WHIPPLE-CALLENDER ARCHITECTS

October 24, 2014

RE: 828 Riverside St., Portland Me.

Outlined below is the info for the General Code and Fire Department requirements:

A1.2

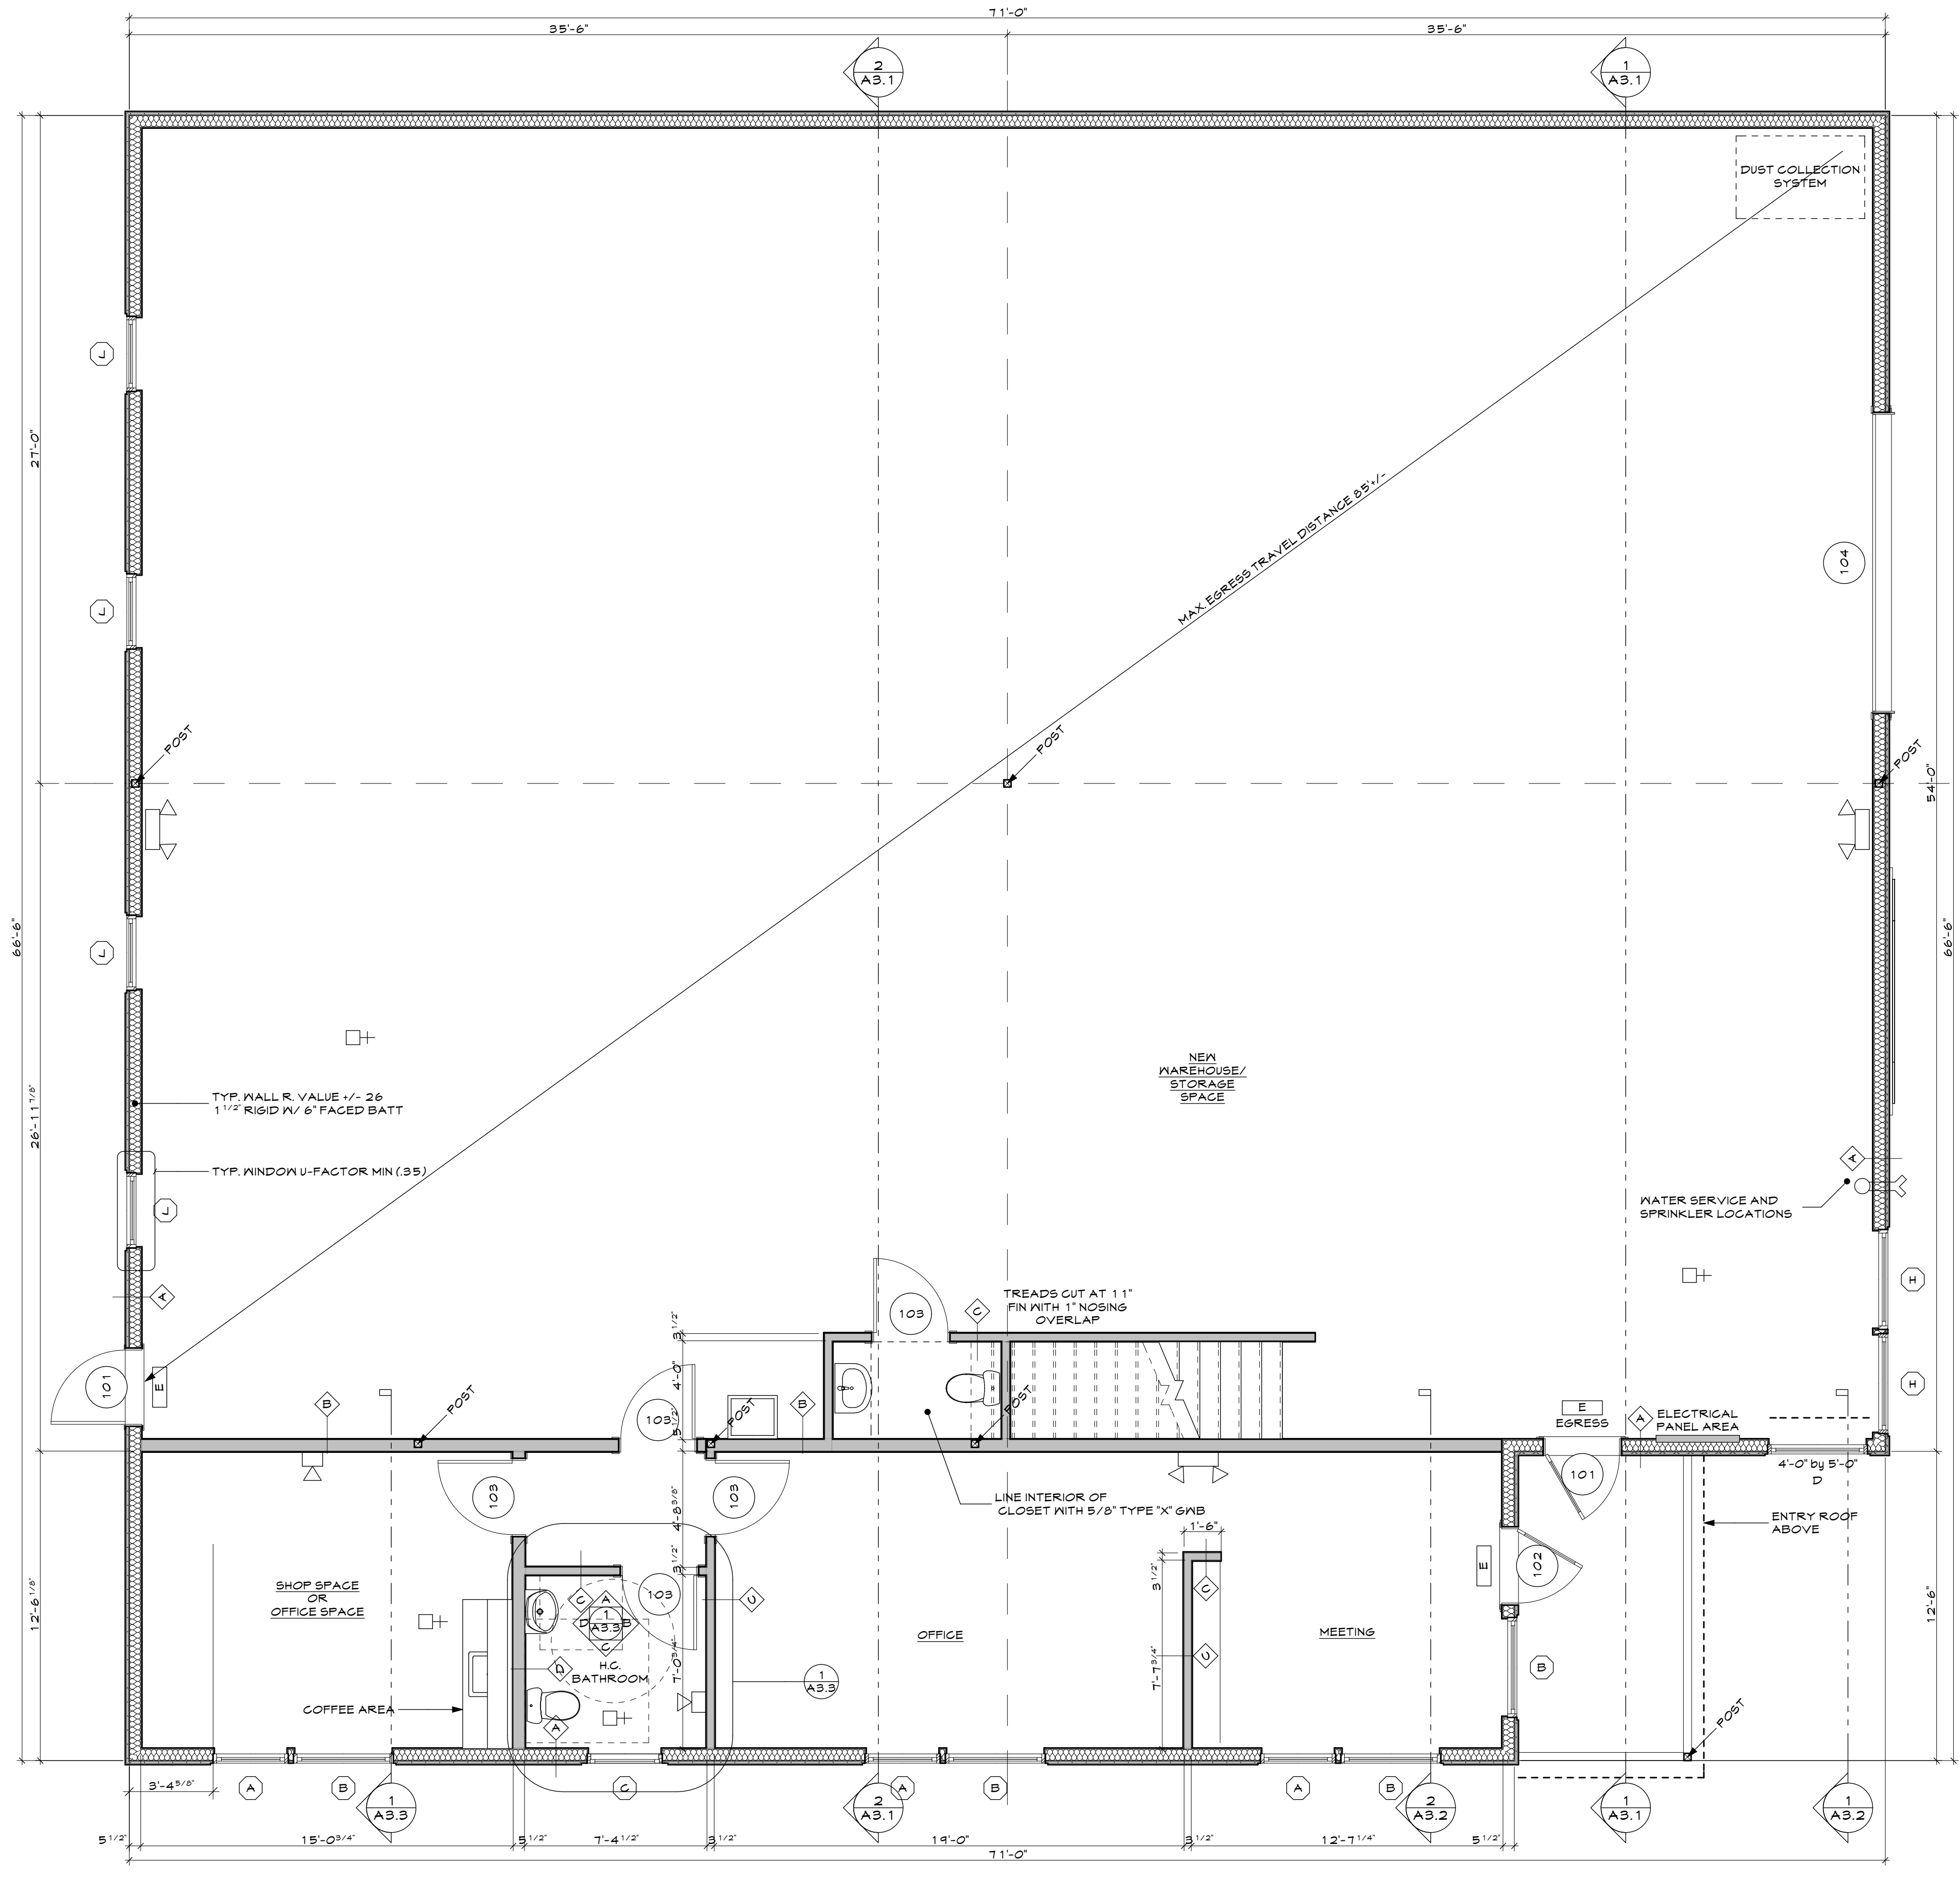
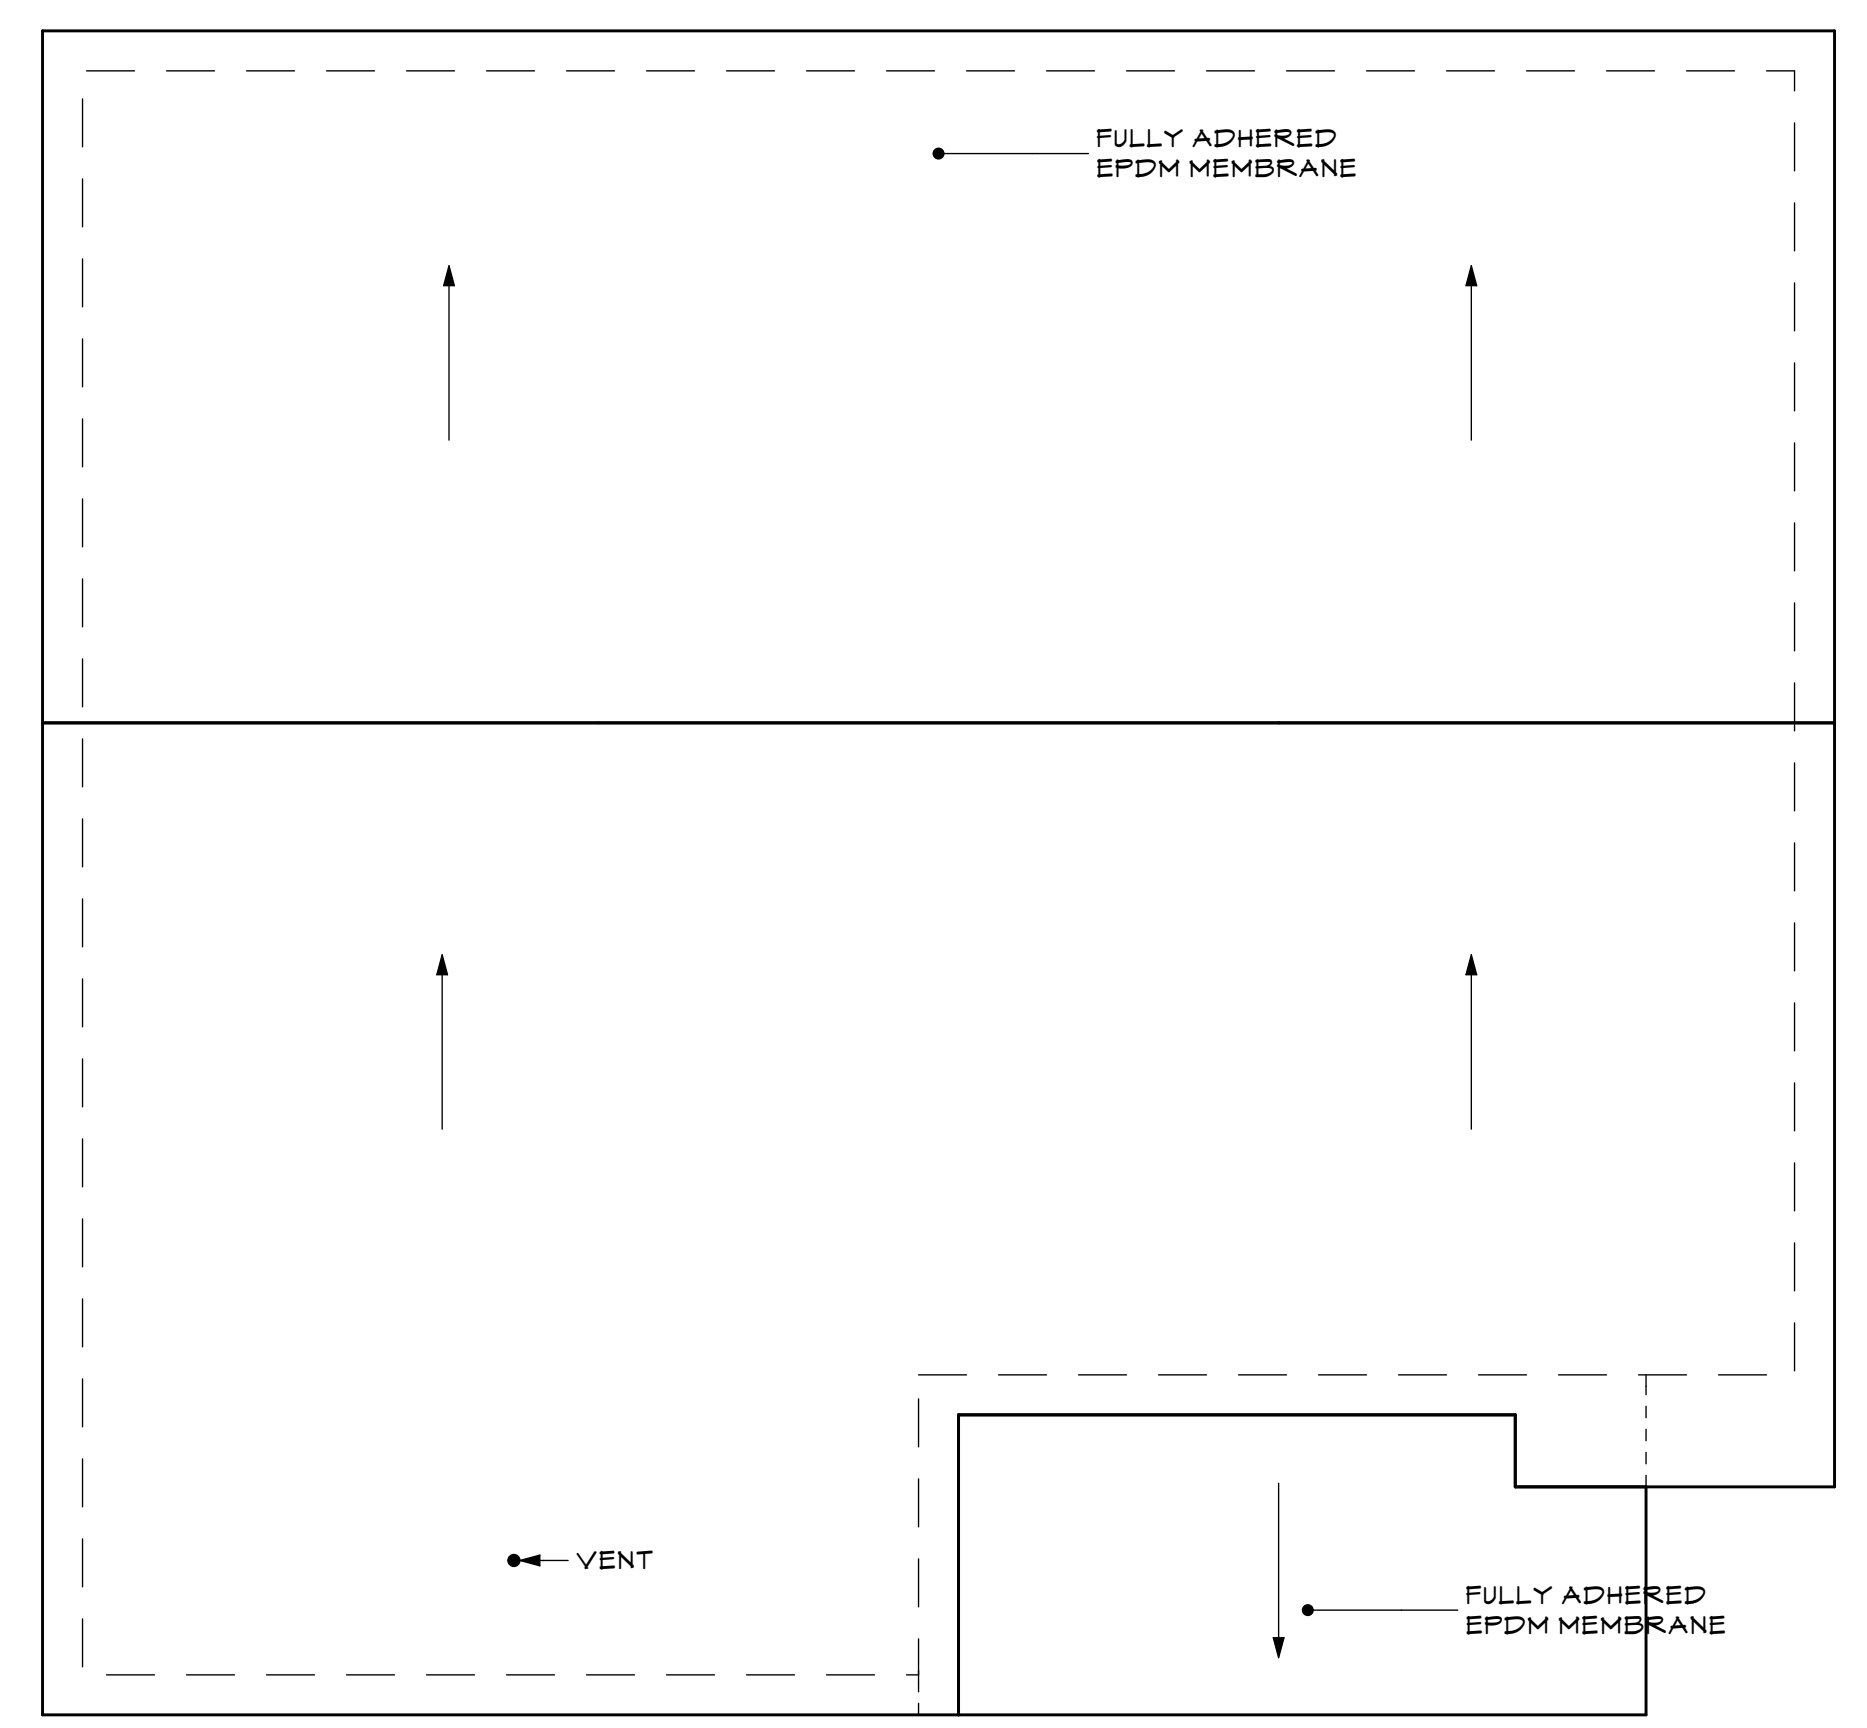
Please provide the additional requirement of 1015.1, which is the common path of travel in 1014.3 (deleted by MUBEC with NFPA Table A.7.6 inserted

Please include Sec. 903.2.4 to justify no sprinkler protection in the F-1 use. Sec. 503 is only for construction type requirements

Please provide the calculations per occupied area

Fire Department checklist- please refer to plan for travel distance, F.E. locations, emergency lighting, exit signs.
